**EL PASO COUNTY PLANNING AND  
 COMMUNITY DEVELOPMENT  
 DEPARTMENT**

**STORMWATER MANAGEMENT PLAN CHECKLIST**

**The Hills at Lorson Ranch**

**THE HILLS AT LORSON RANCH  
 OVERLOT EARLY GRADING AND  
 EROSION CONTROL PLAN**

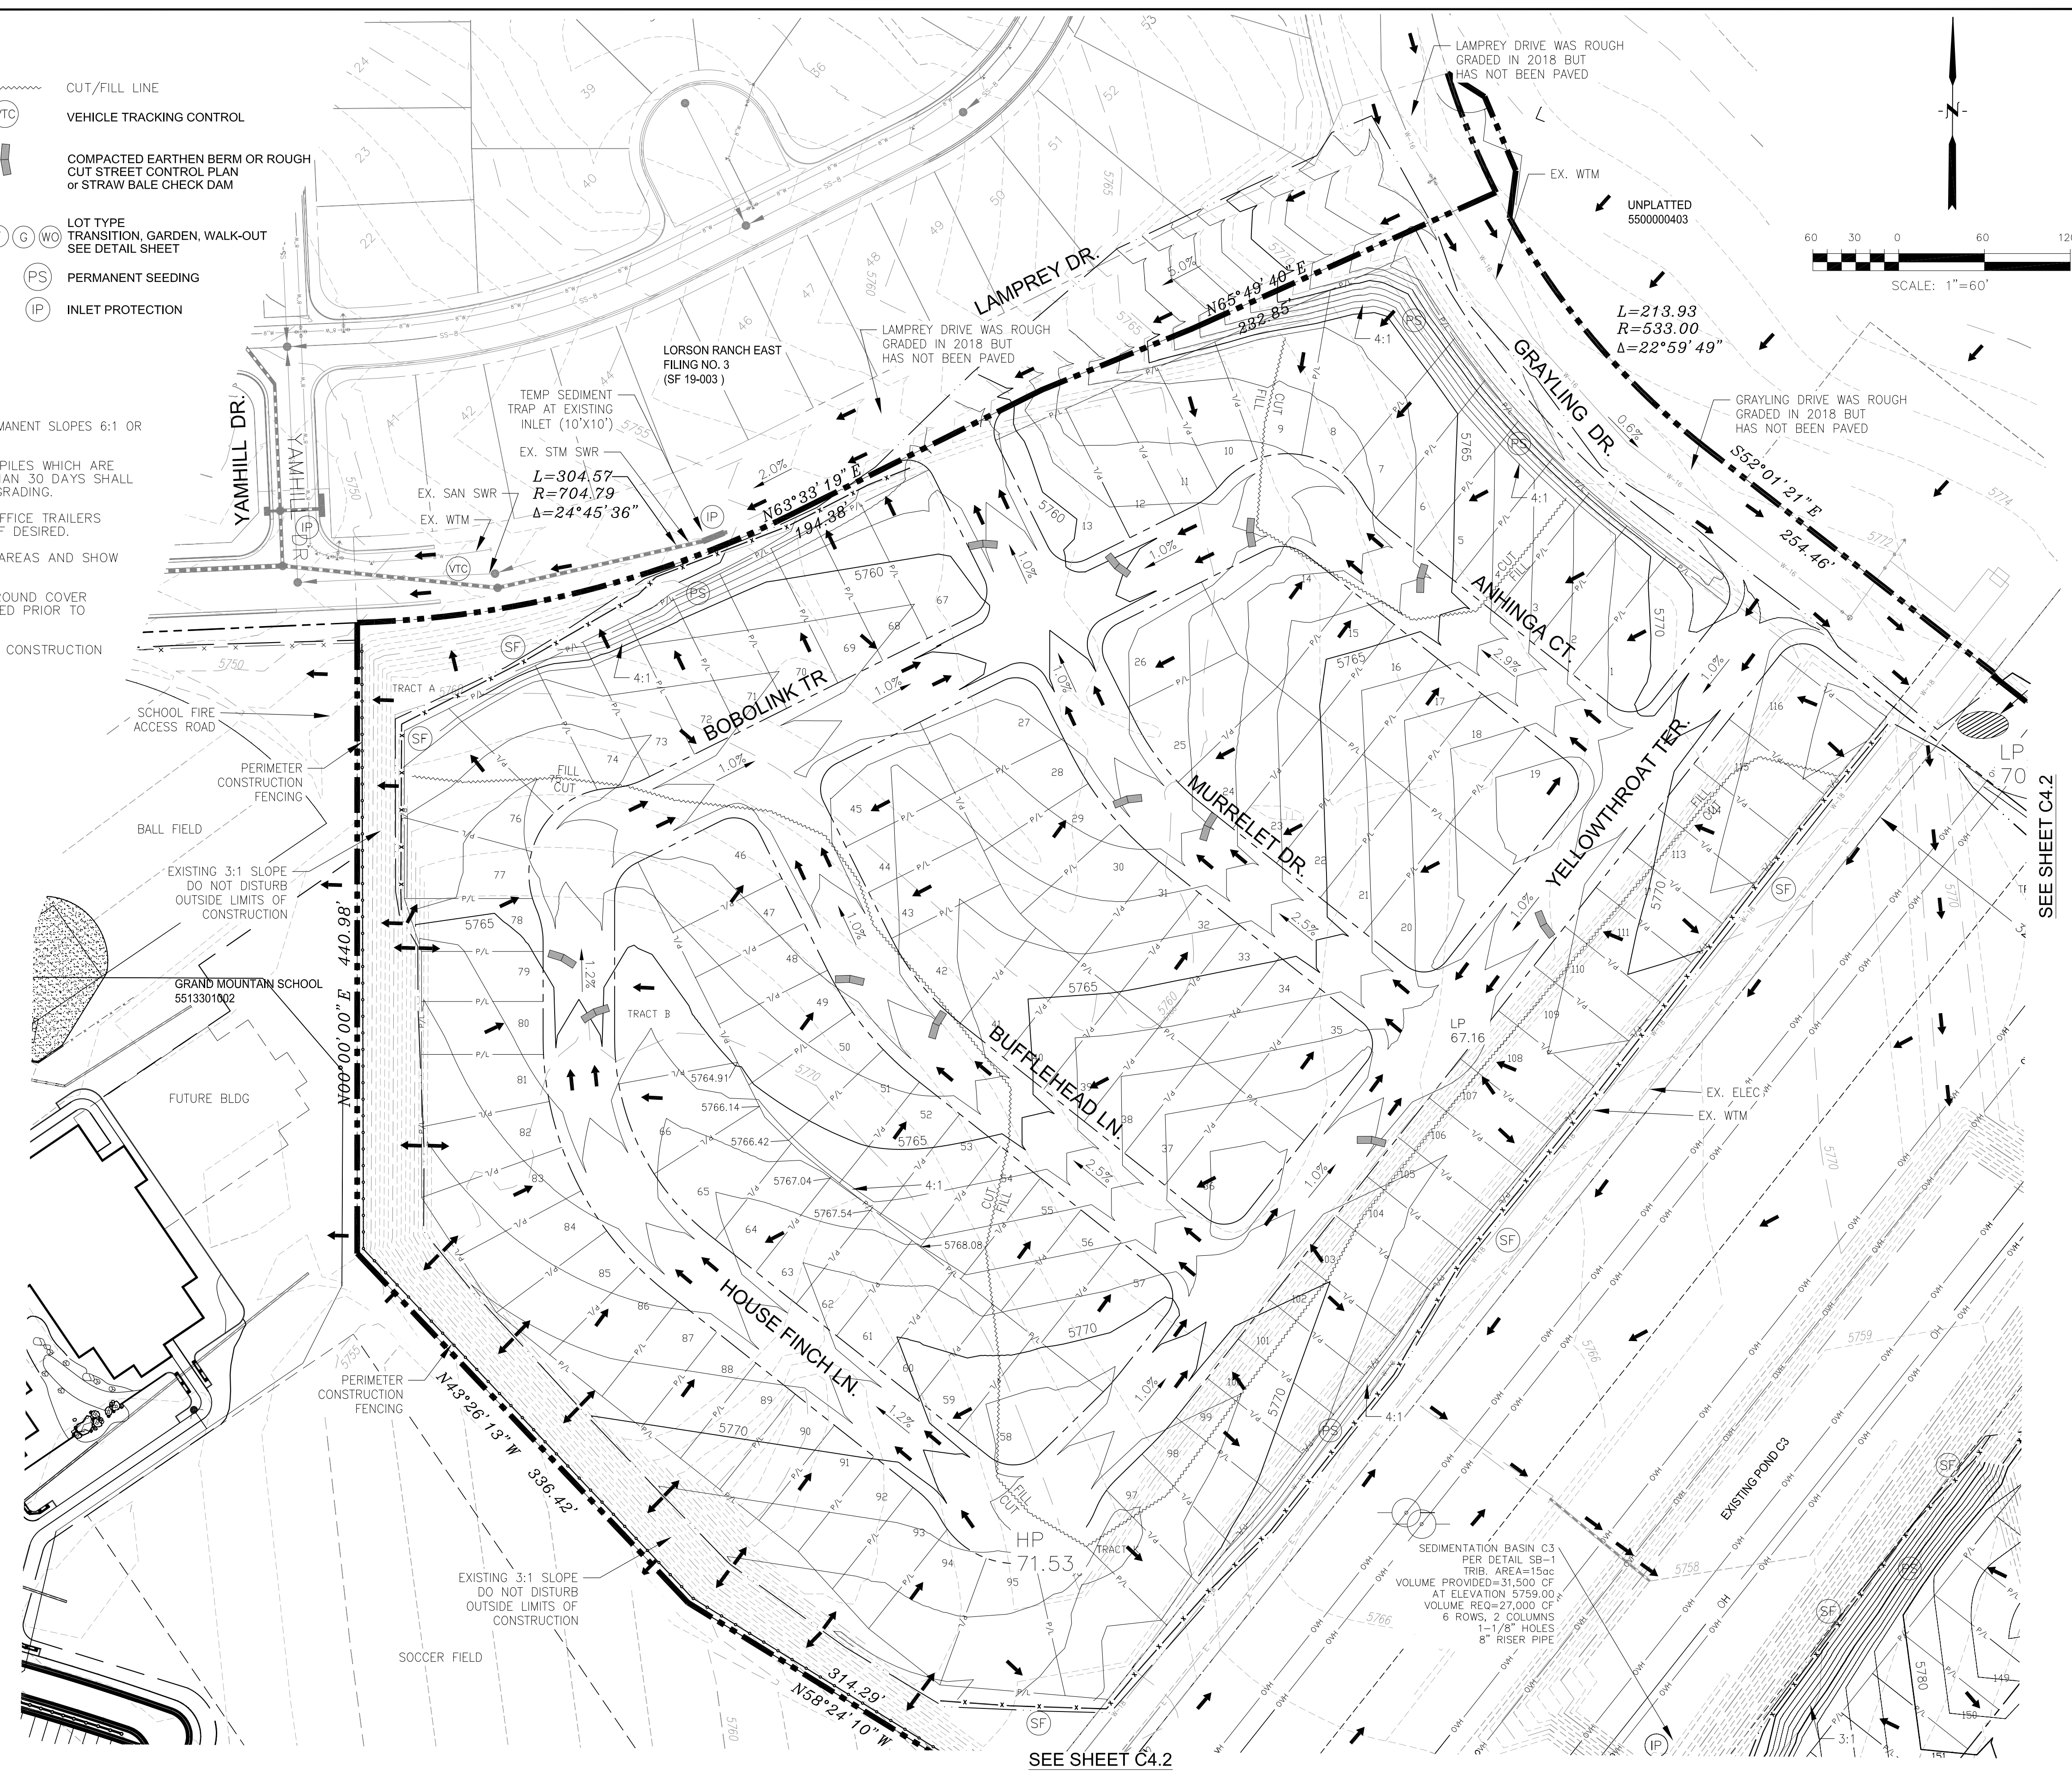
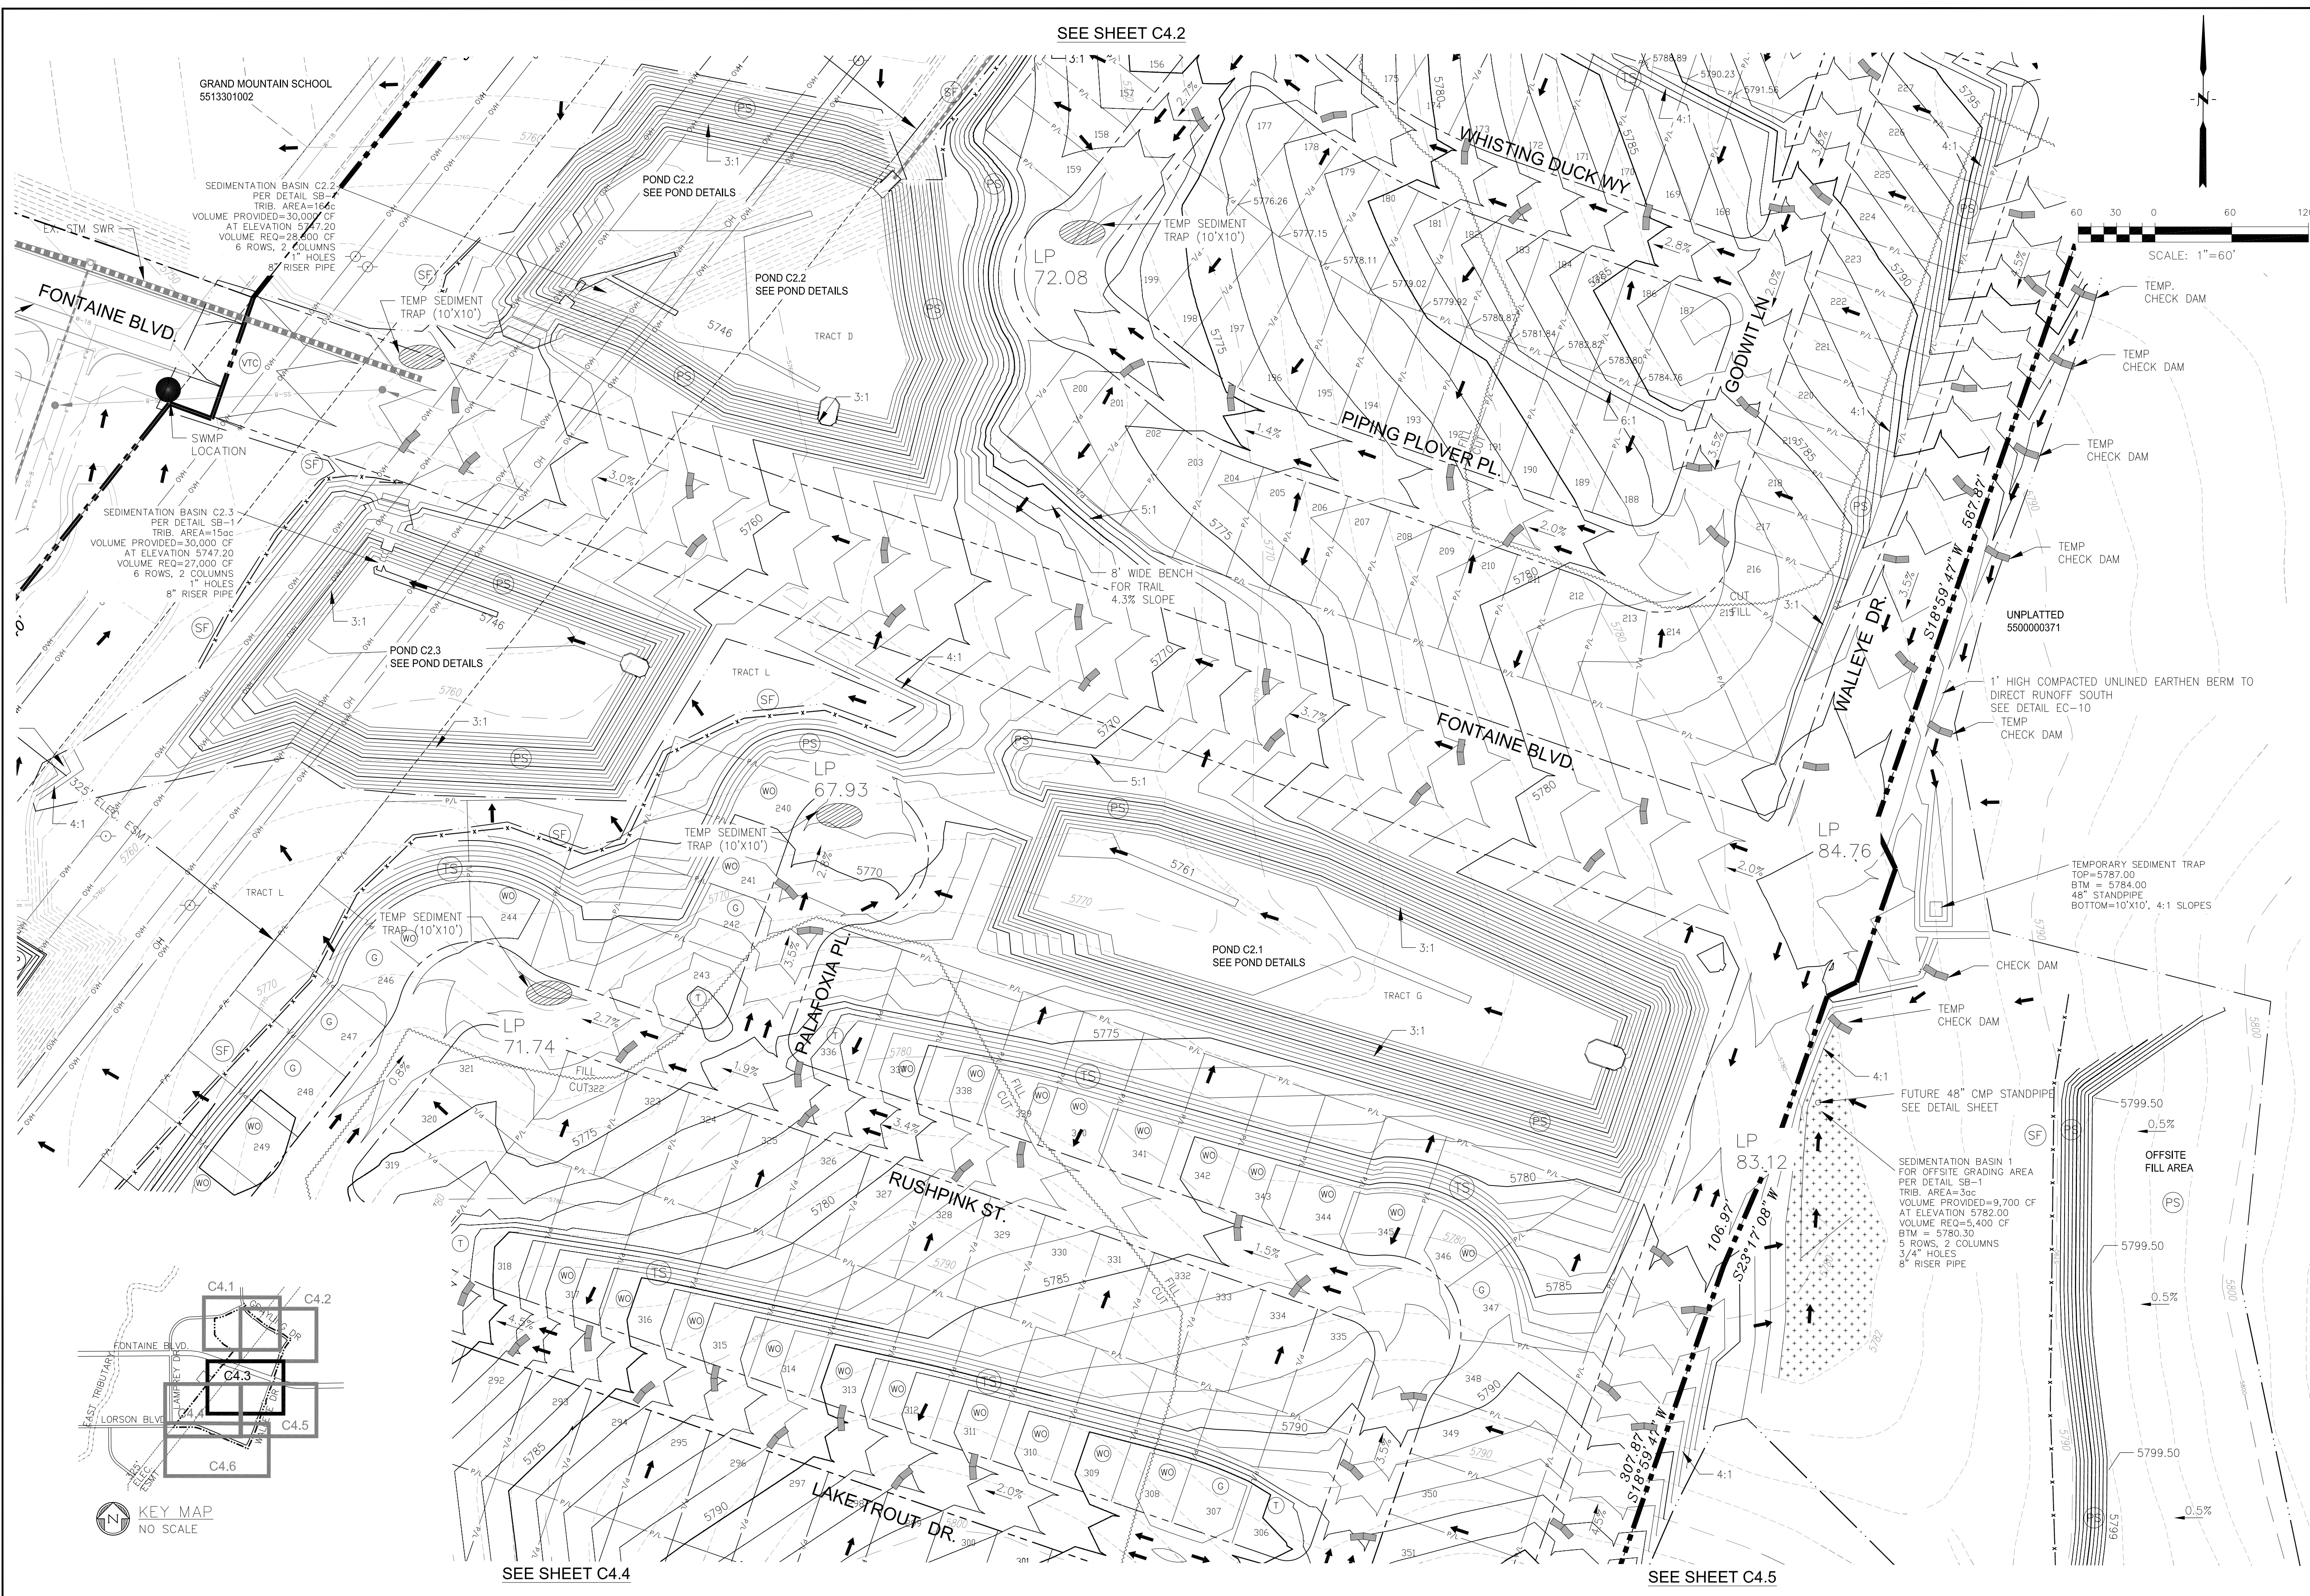
Applicant	PCD
17	SWMP Map to include: <b>Reviewed GEC Plan V_1</b>		
17a	construction site boundaries	y	✓
17b	flow arrows to depict stormwater flow directions	y	✓
17c	all areas of disturbance	y	X
17d	areas of cut and fill	y	✓
17e	areas used for storage of building materials, soils (stockpiles) or wastes	y	✓
17f	location of any dedicated asphalt / concrete batch plants (No batch plants on-site)	n/a	✓
17g	location of all structural control measures	Y	✓
17h	location of all non-structural control measures	Y	X
17i	springs, streams, wetlands and other surface waters, including areas that require maintenance of pre-existing vegetation within 50 feet of a receiving water (No areas require maintenance of pre-existing vegetation)	n/a	✓
18	Narrative description of all structural control measures to be used. Modifications to EPC standard control measures must meet or exceed County-approved details.	y	✓
19	Description of all non-structural control measures to be used including seeding, mulching, protection of existing vegetation, site watering, sod placement, etc.	y	✓
